from
**Southern
Water**

Your ref
P/22/22/PL

Proposal: Variation of condition 1 imposed under P/132/20/PL relating to approved plans.
Site: P/22/22/PL: - Land West of Hook Lane, Pagham, PO21 3PB.

Status		Status Date
Preliminary		Feb 2022
Drawn	Checked	Date
RM	RM	04.02.22
Scale	Number	Rev
1:500	10884-SK-03	A
0 10 20 30 40 50		
METRES

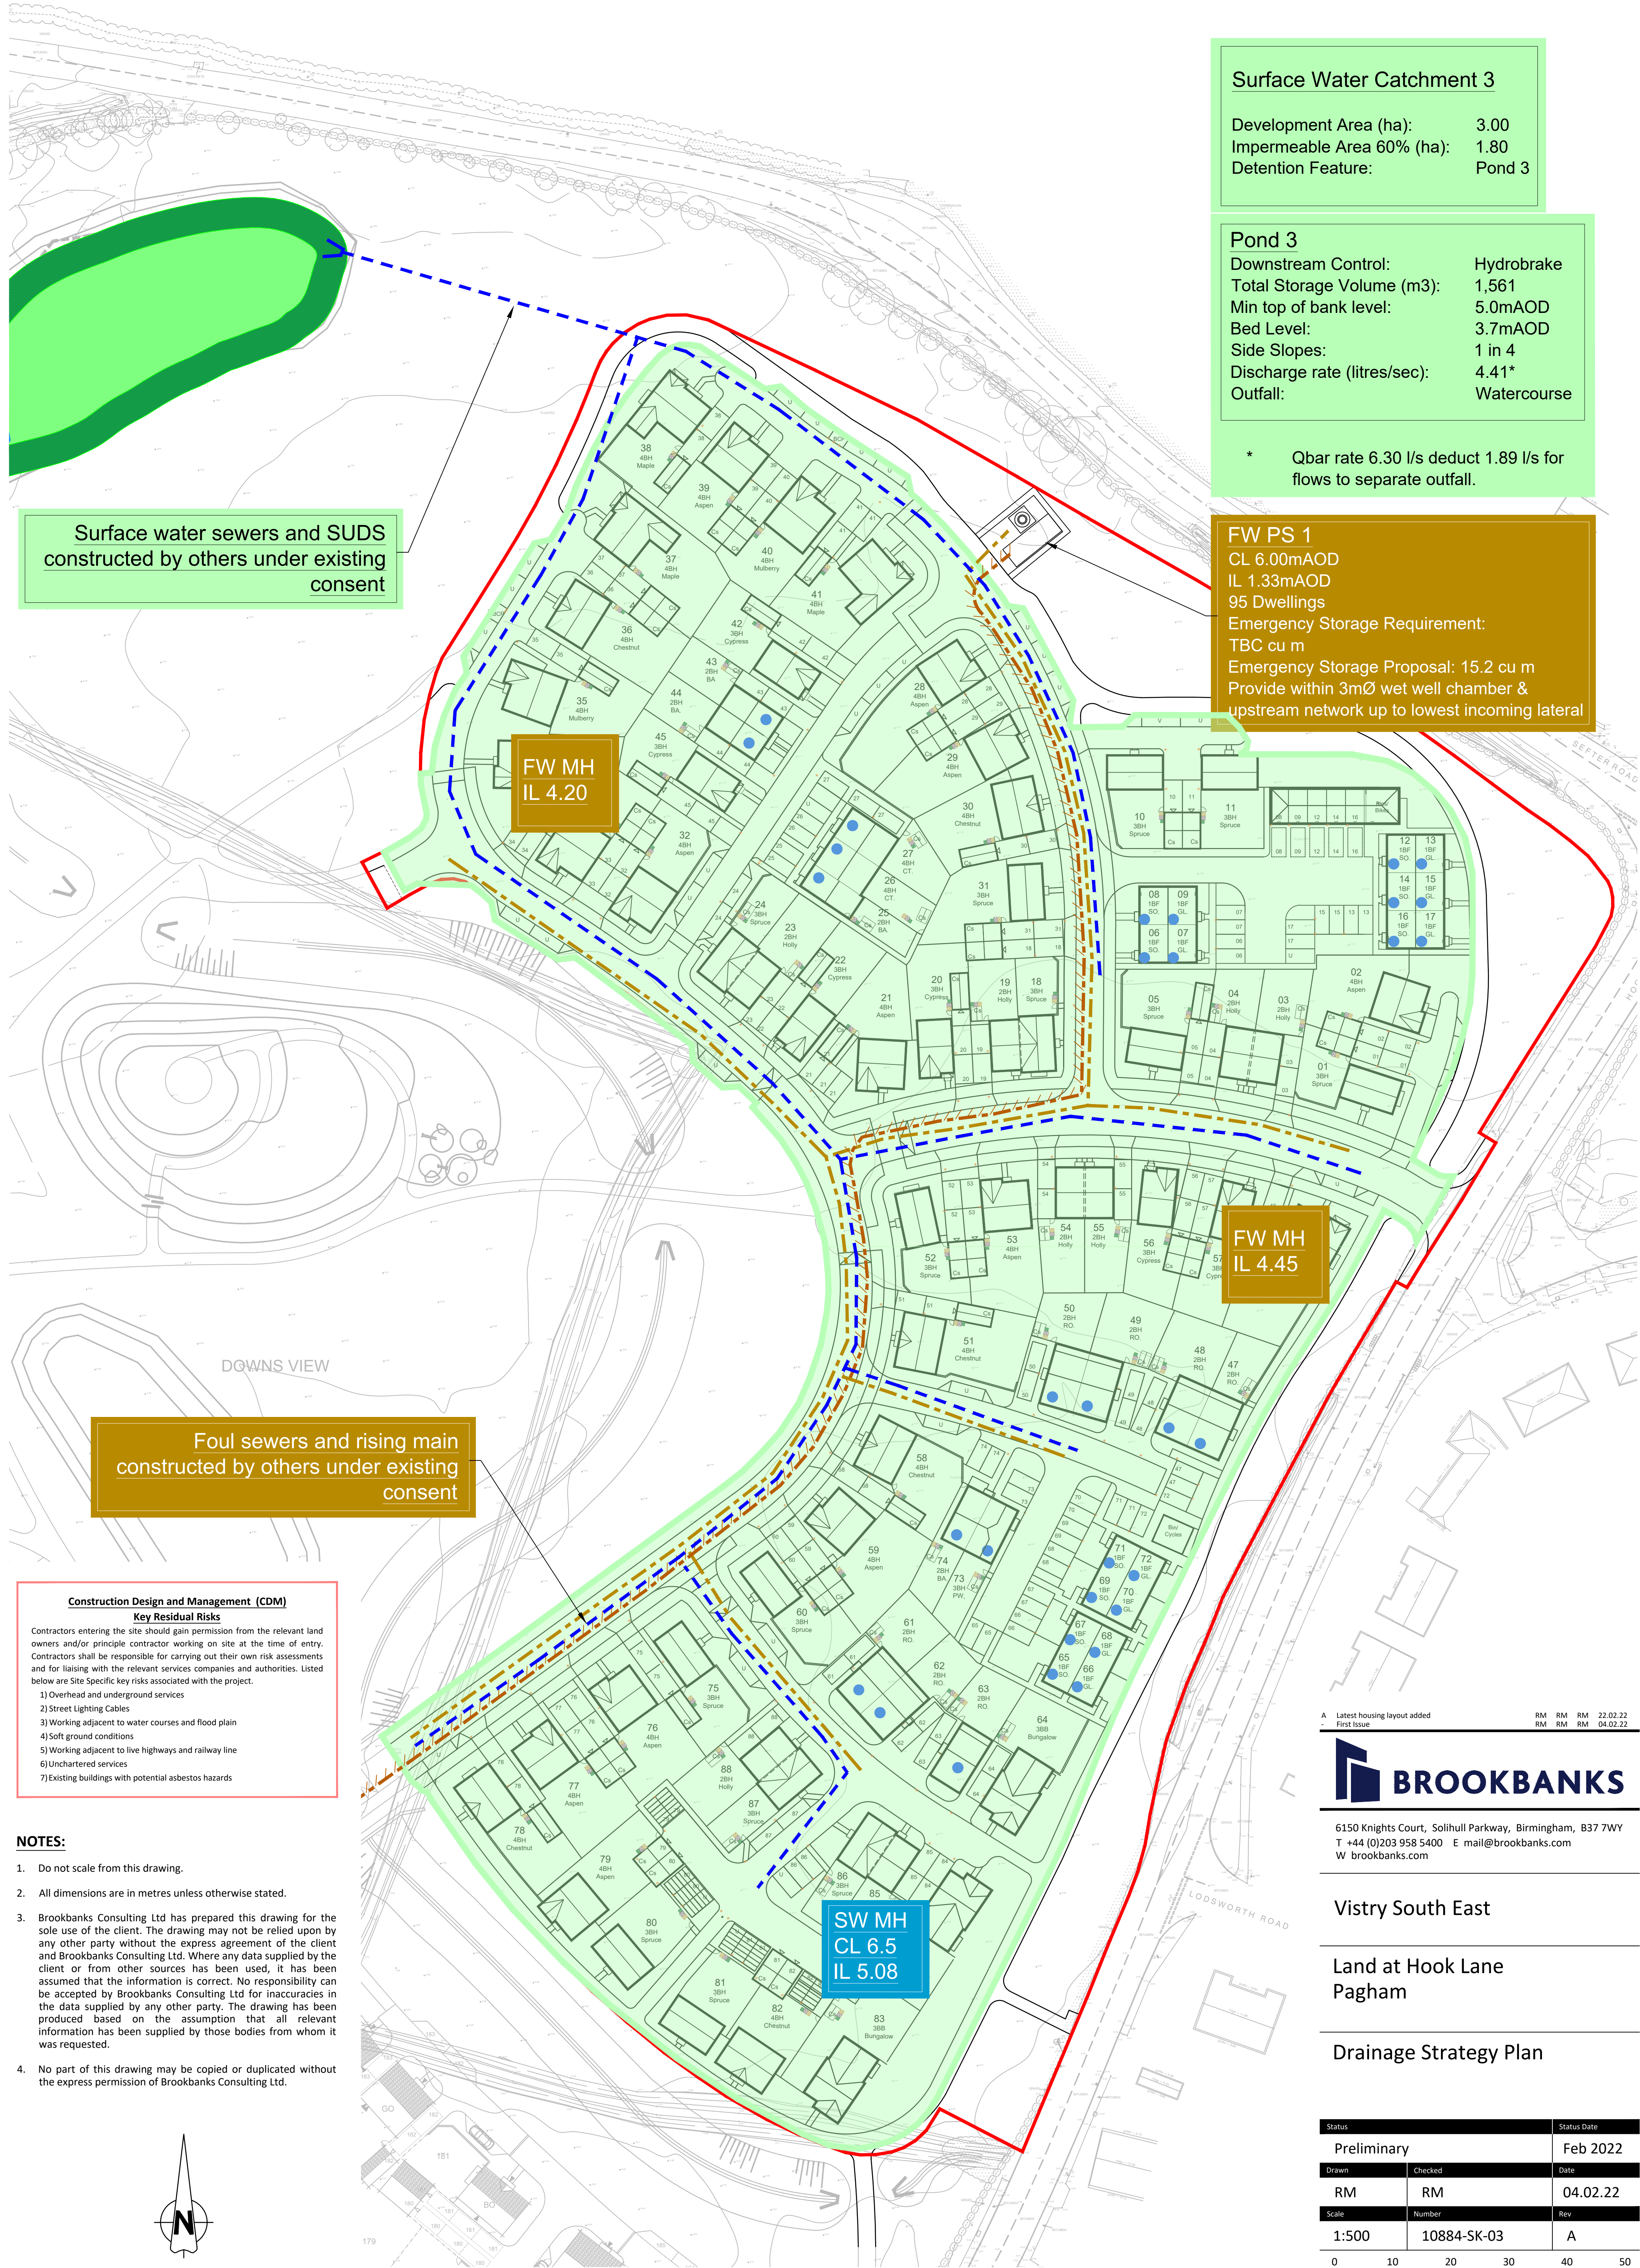
The submitted drainage layout (10884-SK-03 Rev-A) is acceptable to Southern Water.
